***MODIFICATION REQUEST:
Hurstville Private Hospital
37 Gloucester Road, Hurstville
(MP 11_0042 MOD 2)***

Modification to the internal layout, changes to the façade, increase in height of the lift shaft and expanded plant area on the rooftop

Secretary's Environmental Assessment Report
Section 75W of the *Environmental Planning and
Assessment Act 1979*

December 2014

PROJECT:
HURSTVILLE PRIVATE HOSPITAL
TITLE:
SHADOW DIAGRAMS SHEET 1

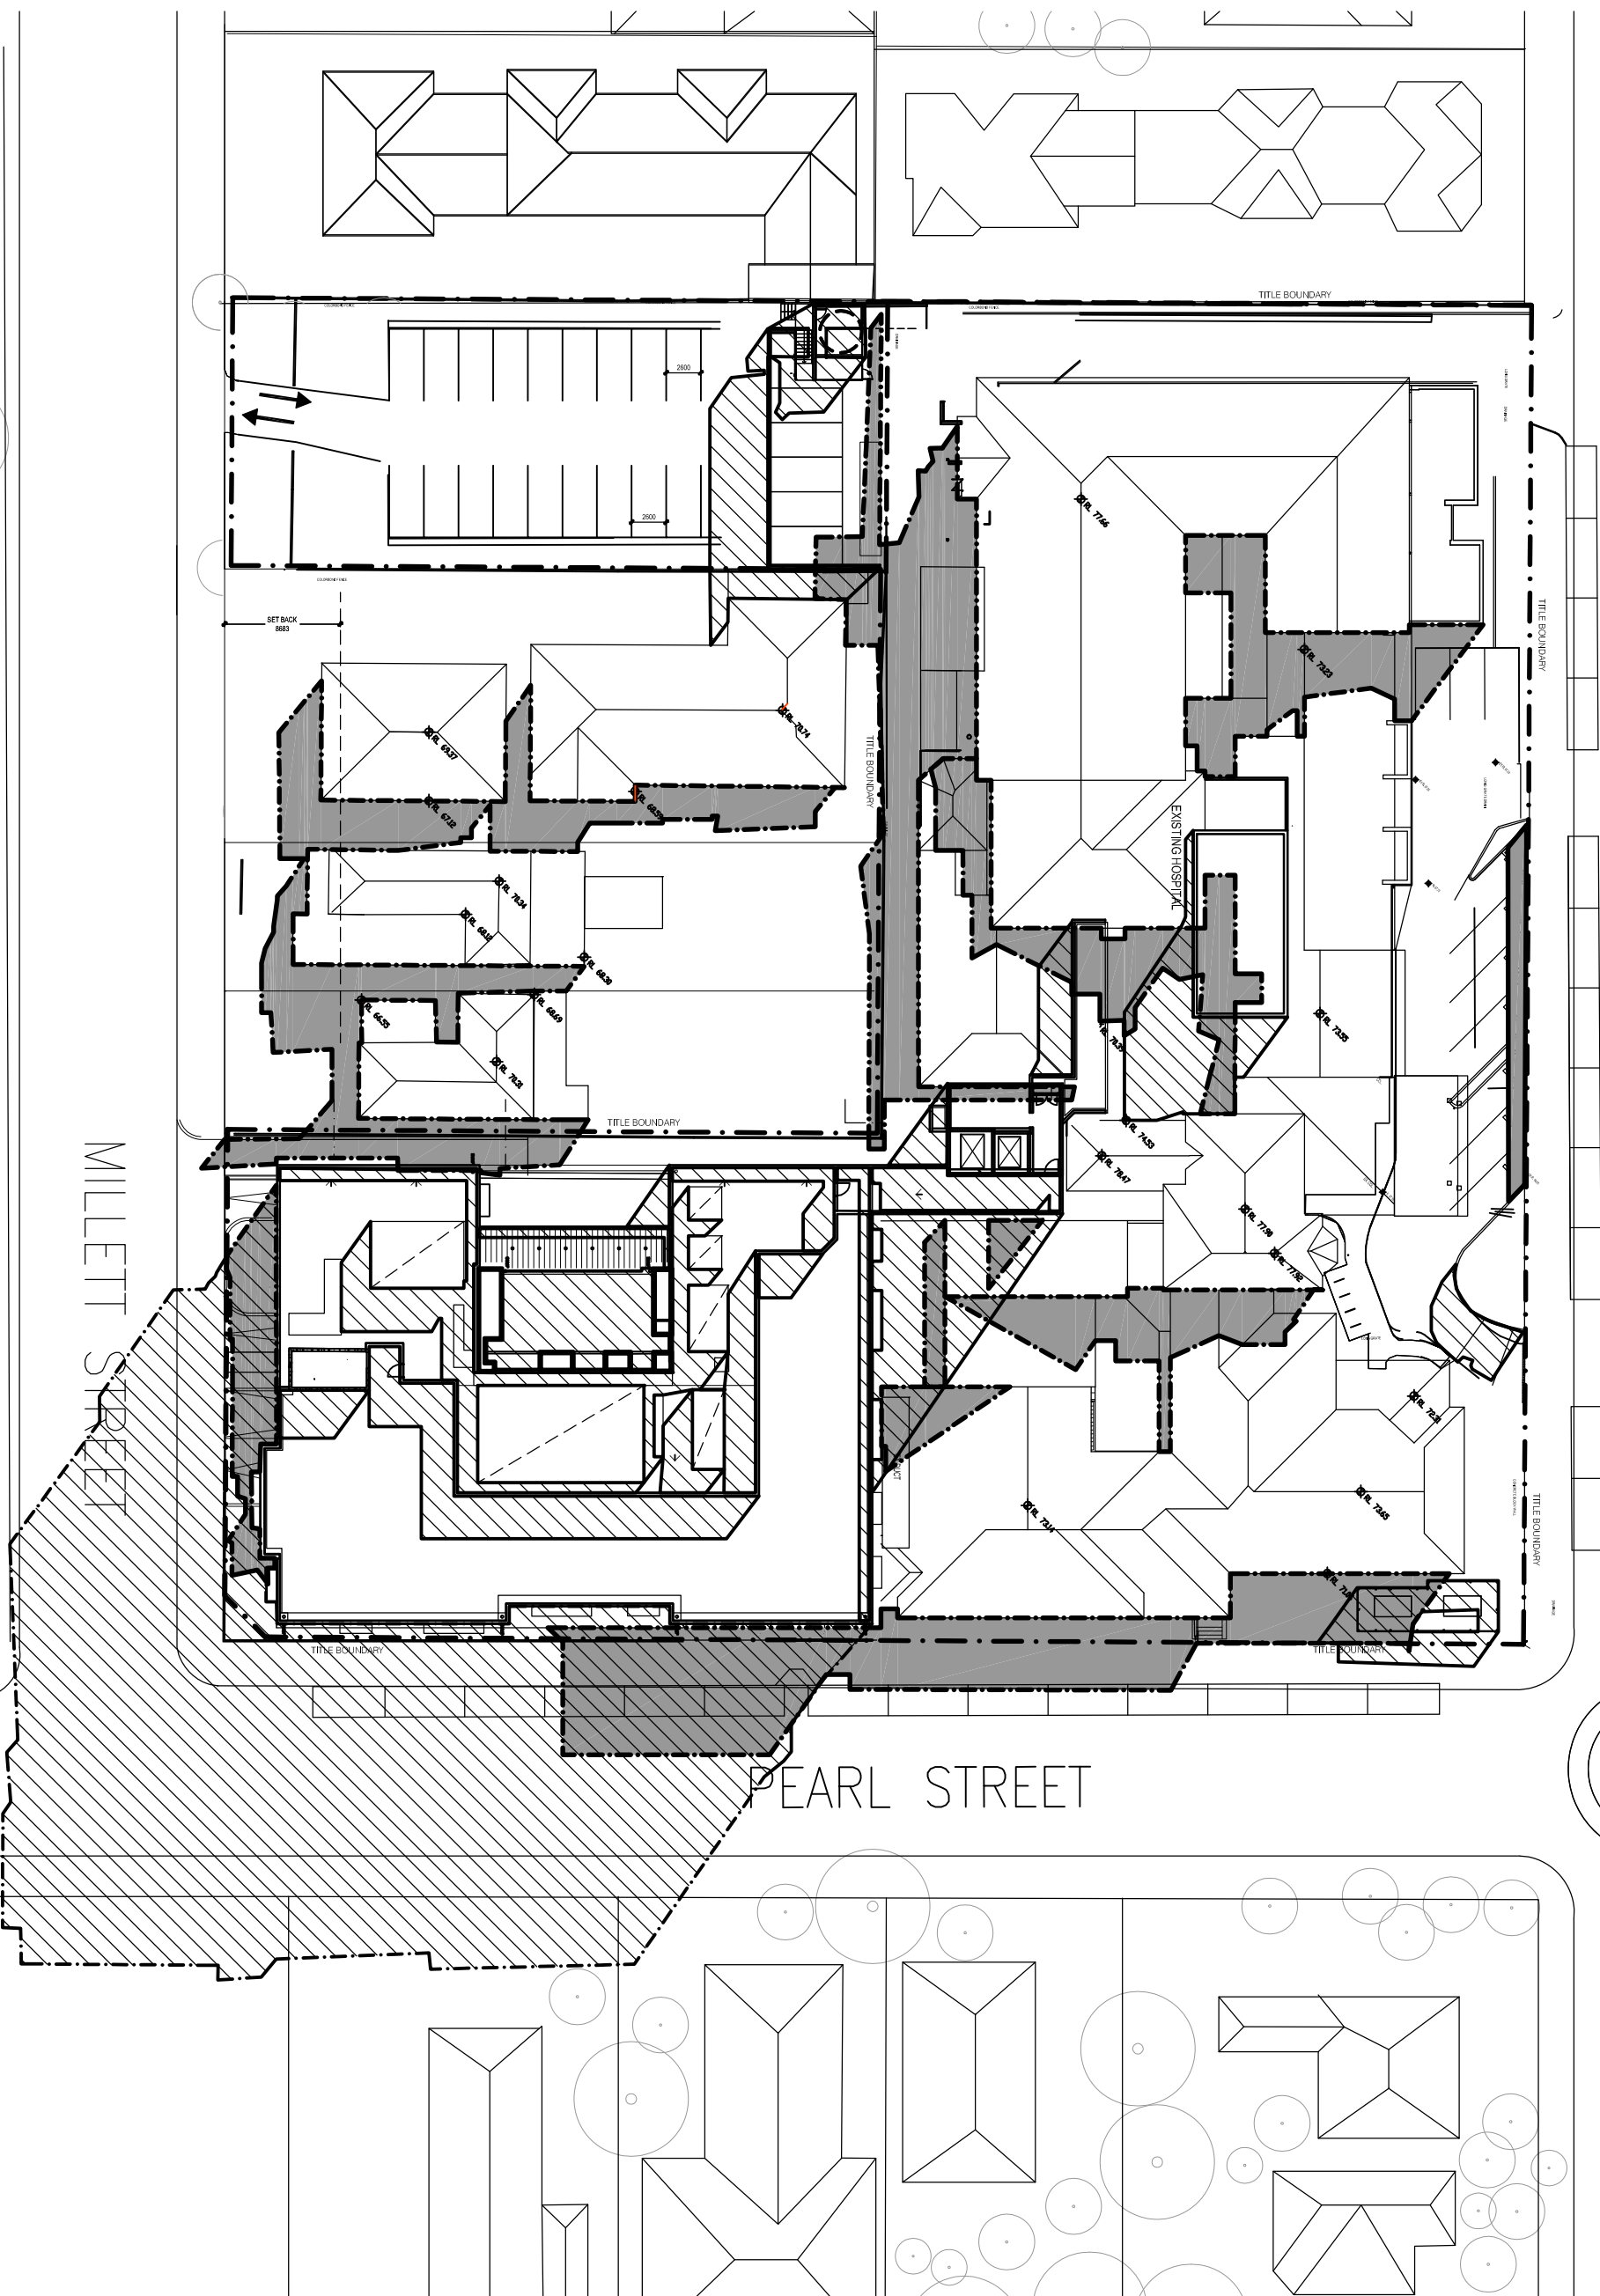
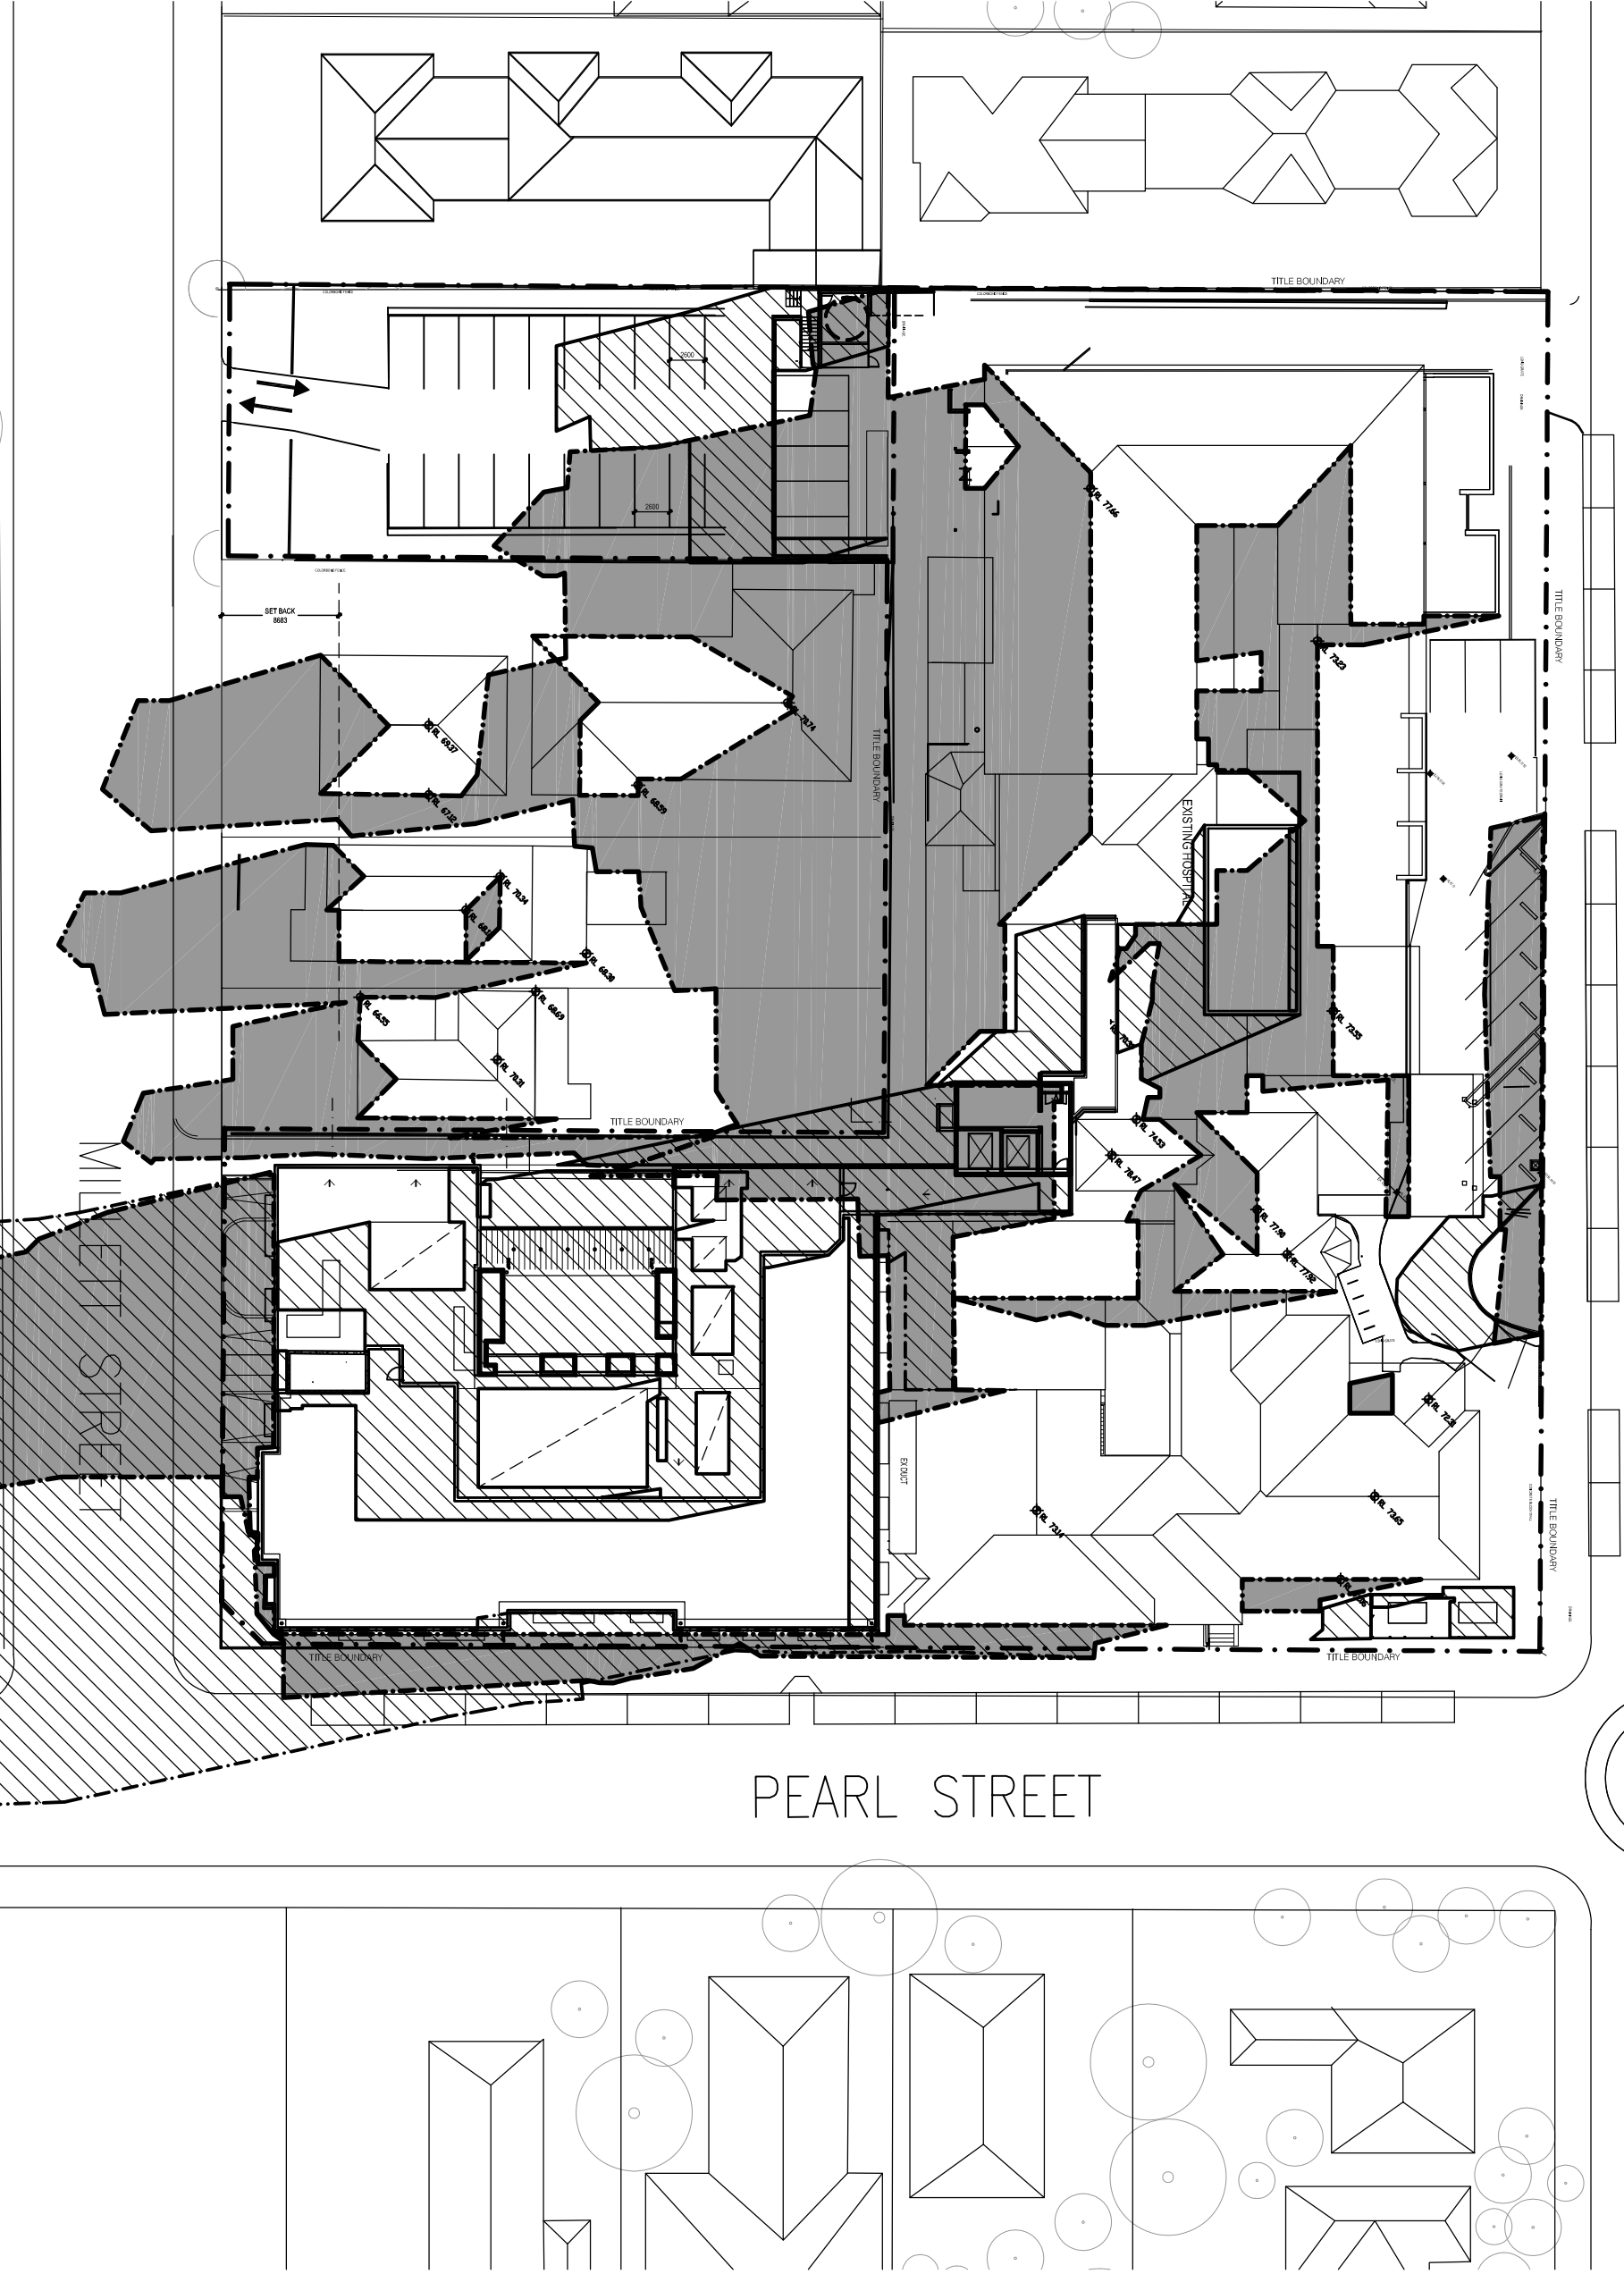
The additional height associated with the lift core also has the potential to adversely impact on the amenity currently enjoyed by the adjoining low scale residential properties directly to the south-west, fronting onto Millett Street. The proposed additional height would be readily visible above the parapet of the main building from these properties. However, the additional height would be offset by the removal of the link-way at the base of the lift core (as a consequence of the link corridor being relocated to the Gloucester Road side of the core), which would introduce a more slender building form (see **Figure 4**). The additional height associated with the lift overrun would also introduce some articulation to the roof line and assist in breaking up the mass of the building when viewed from the rear of the adjacent residential properties. Shadow diagrams submitted with the modification application demonstrate that there will be negligible additional shadow impacts on the rear of residential properties in Millett Street.
